REQUEST

Current Zoning: N1-D (neighborhood 1-D), N2-B (neighborhood 2-B), and B-1(CD) (neighborhood business, conditional)
 Proposed Zoning: N2-A(CD) (neighborhood 2-A, conditional)

Approximately 1.33 acres along the north side of State Street, east of South Turner Avenue, and west of Beatties Ford Road.

The petition proposes the development of up to 29 multi-family attached dwelling units. The site is currently developed with a commercial building and a material storage yard.

RZ.01

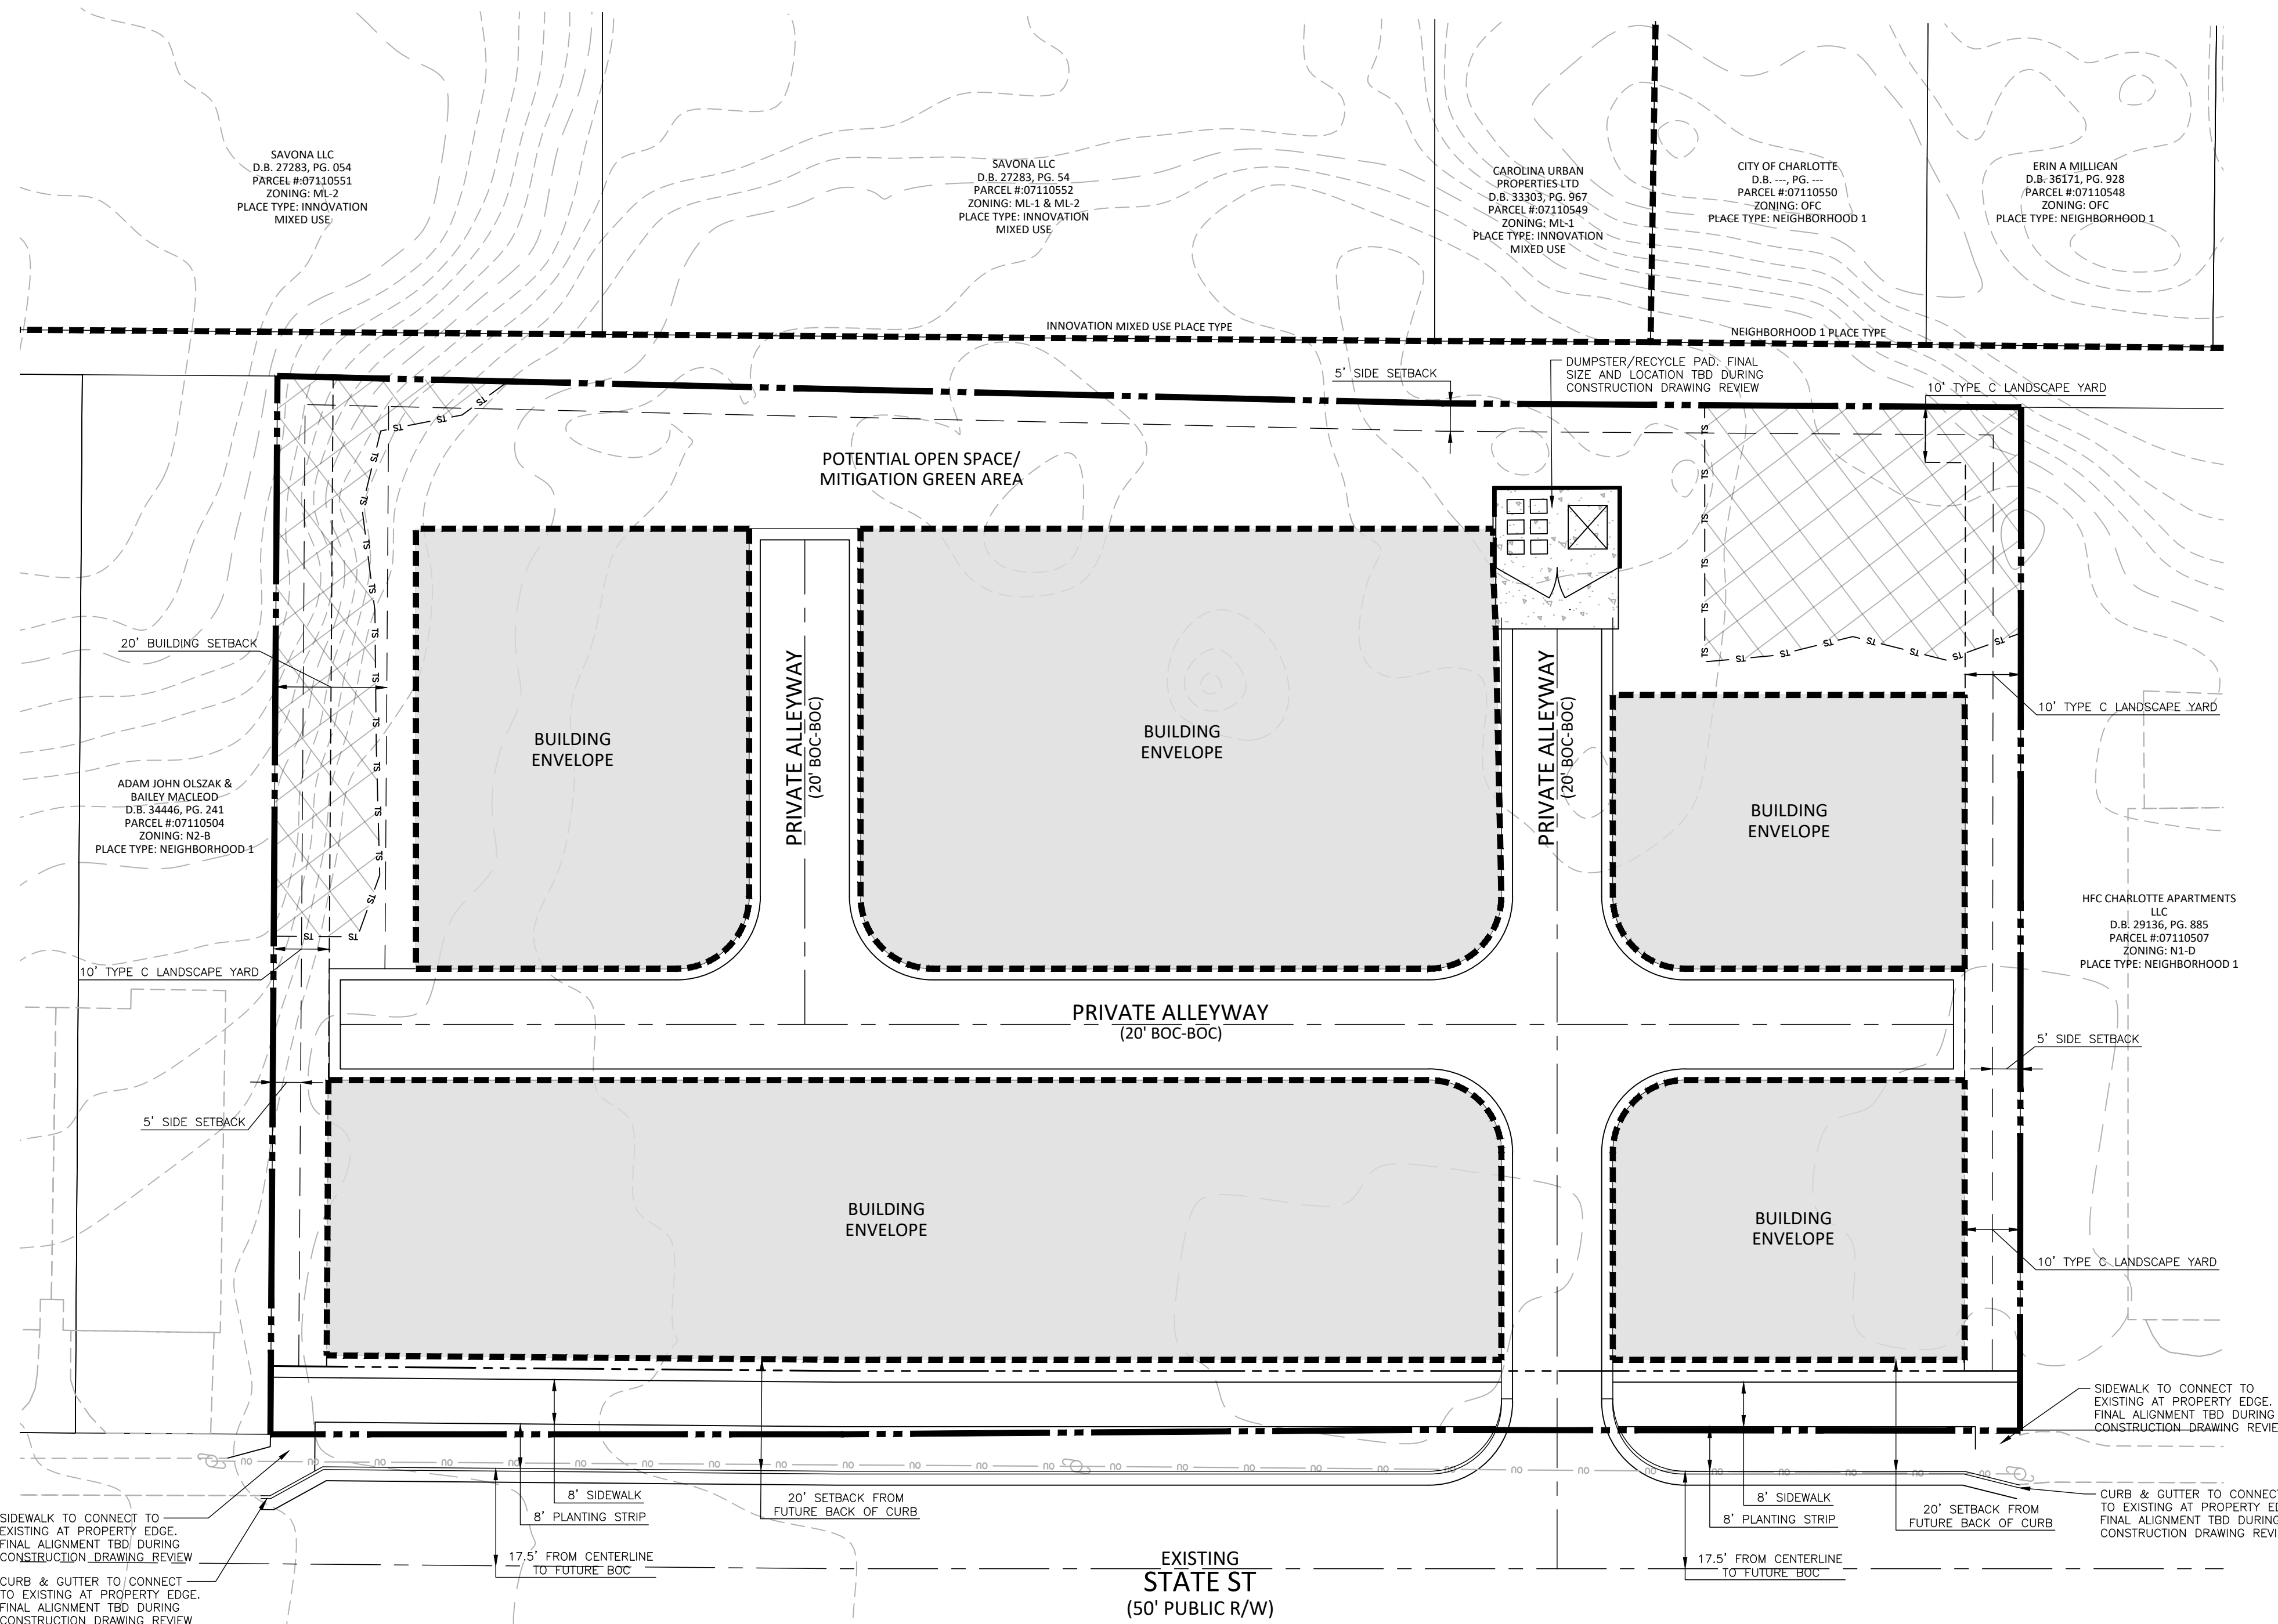
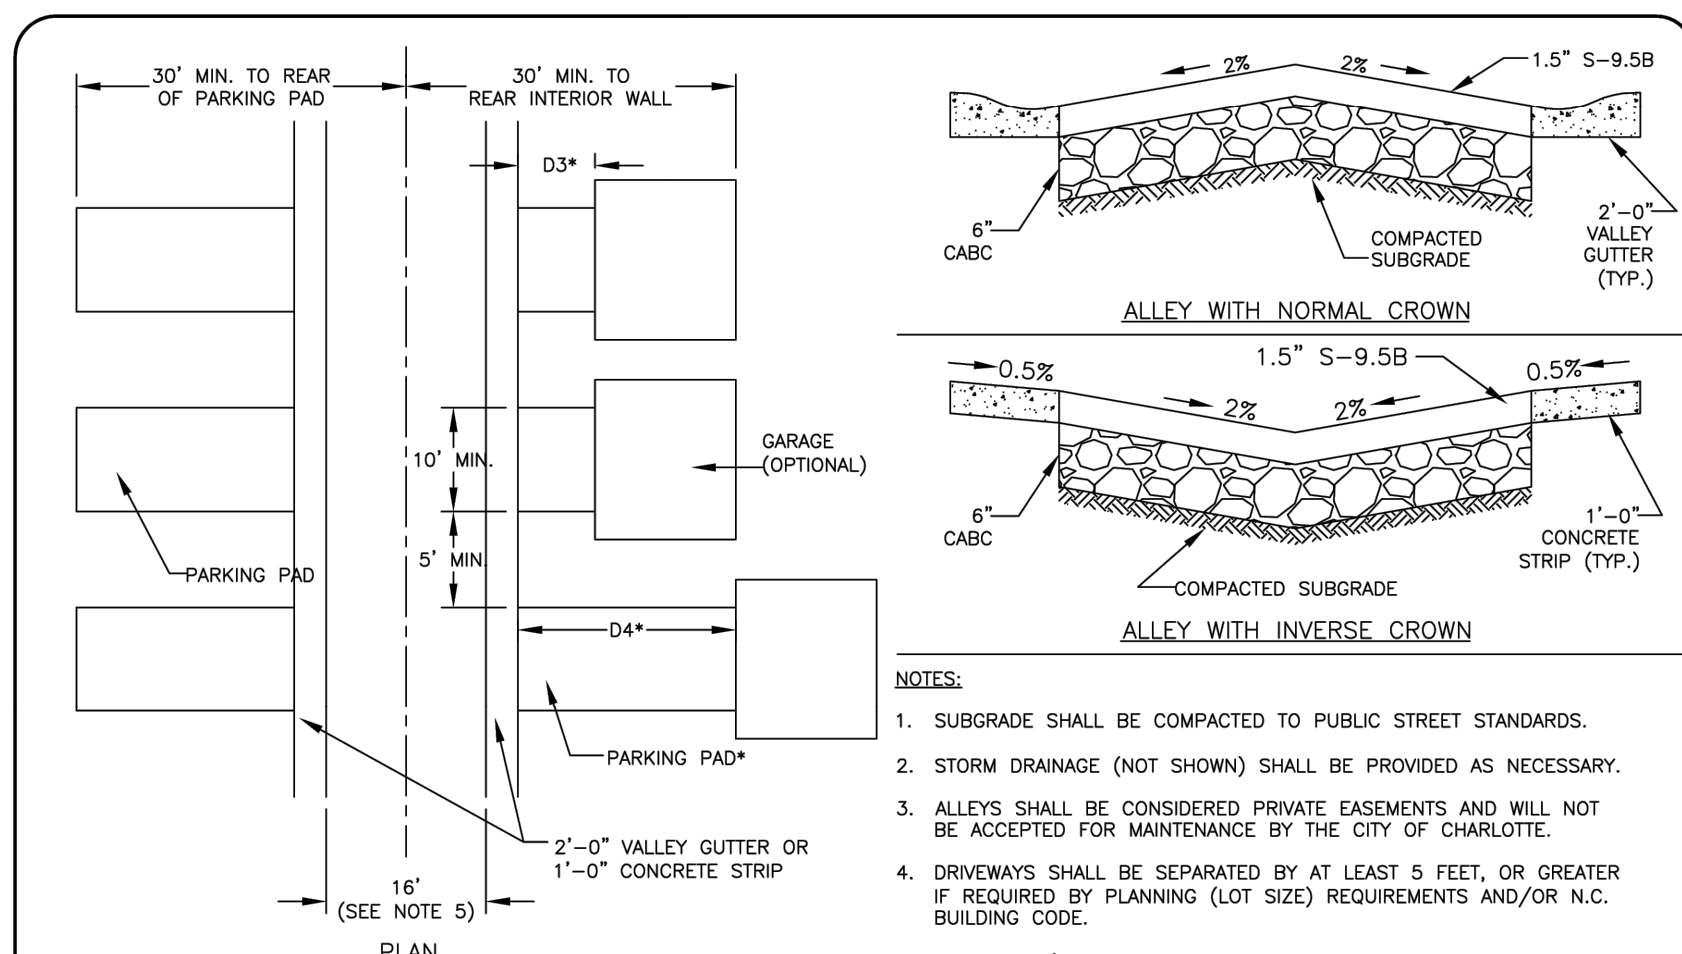
1. Entitlement Services: specify a minimum number and maximum spacing for proposed alley street trees: **Addressed**
